Application No: FP/66/26/PL
Site Address: Rabbit Island Rear of 84 Brooks Lane Bognor Regis PO22 8DN
Description of works: Retention of an existing agricultural barn previously approved under FP/106/23/AG with a total roof height of 3.99m (compared to 2.9m as permitted). This application is in CIL Zone 5 (Zero Rated) as other development.

Thank you for your internet representation made on 29th July 2026 which has been recorded as an objection with the comments as follows:

Drawing: Elevations and floor plan

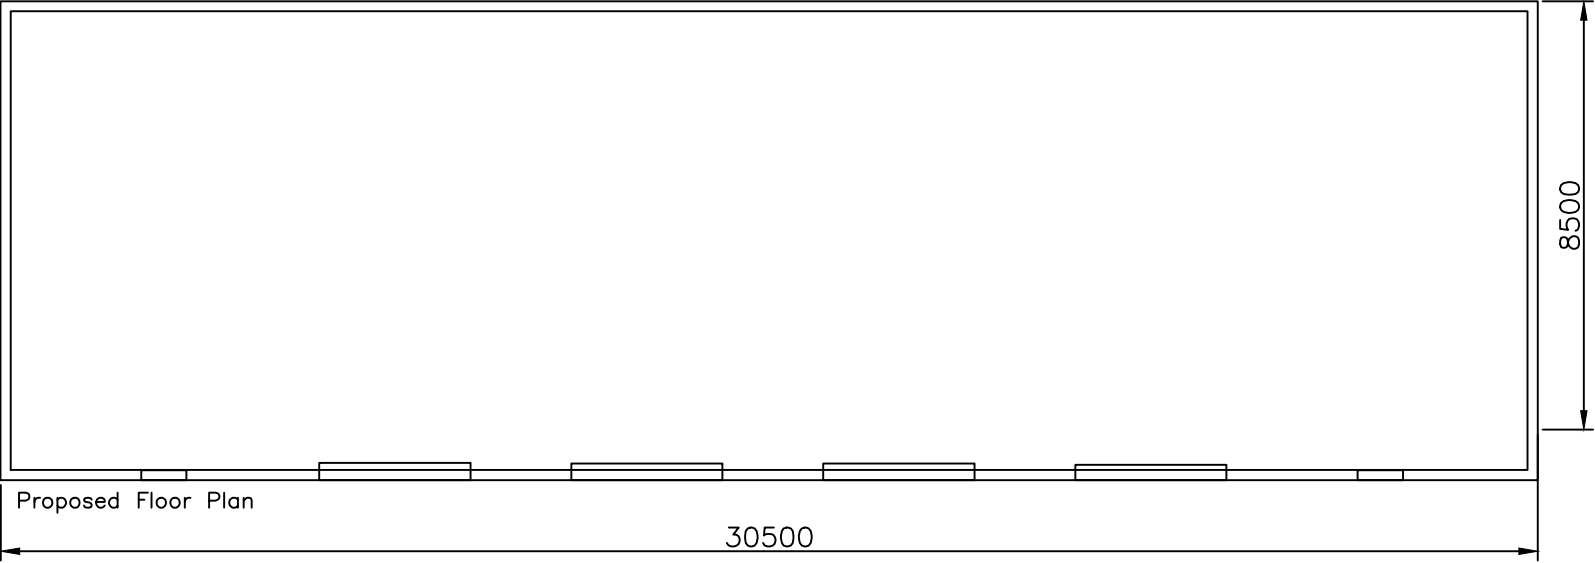
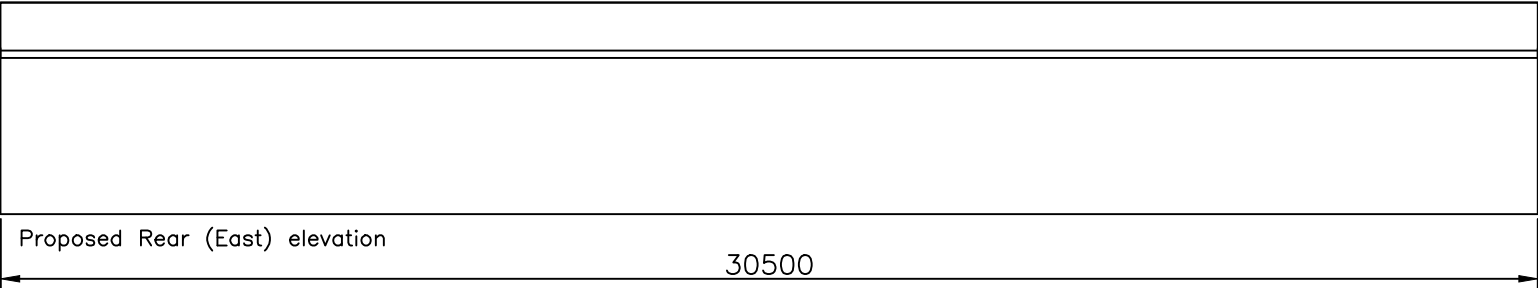
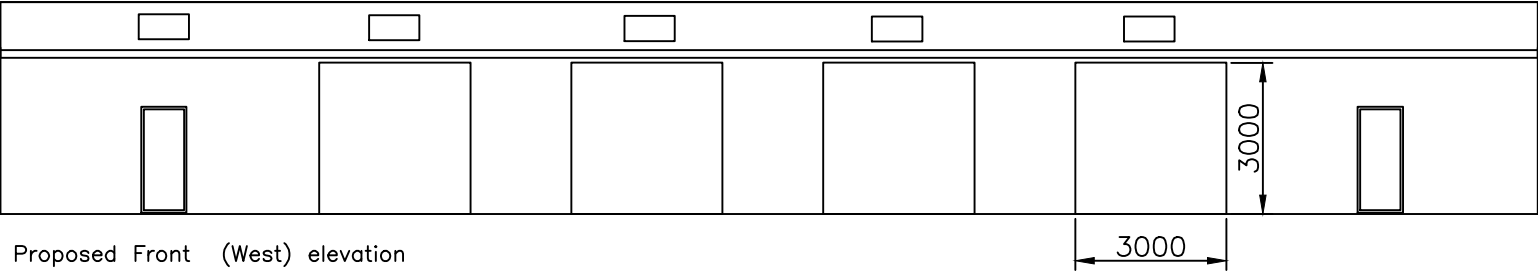
The structure has been built significantly higher than the height authorised. This constitutes a clear breach of the approved plans and therefore represents unauthorised development. Allowing retrospective approval would undermine confidence in the planning process and set an undesirable precedent for applicants to disregard permitted dimensions.

The increased height has resulted in a building that is visually intrusive, out of scale with surrounding agricultural structures, and detrimental to the rural character of the area. The barn now appears dominant in the landscape, contrary to policies requiring development to respect local setting and minimise visual harm.

Due to its excessive height, the barn causes overbearing impact on nearby properties, reducing the sense of openness and altering established views. This impact would not have occurred had the structure been built in accordance with the approved height.

No adequate justification has been provided for the height exceeding the permitted dimensions. The deviation

appears unnecessary for agricultural function and therefore fails to demonstrate any material planning benefit that would outweigh the harm caused.

For the reasons outlined above, I respectfully request that Arun District Council refuse the application for retention and require the structure to be altered to comply with the originally approved height.
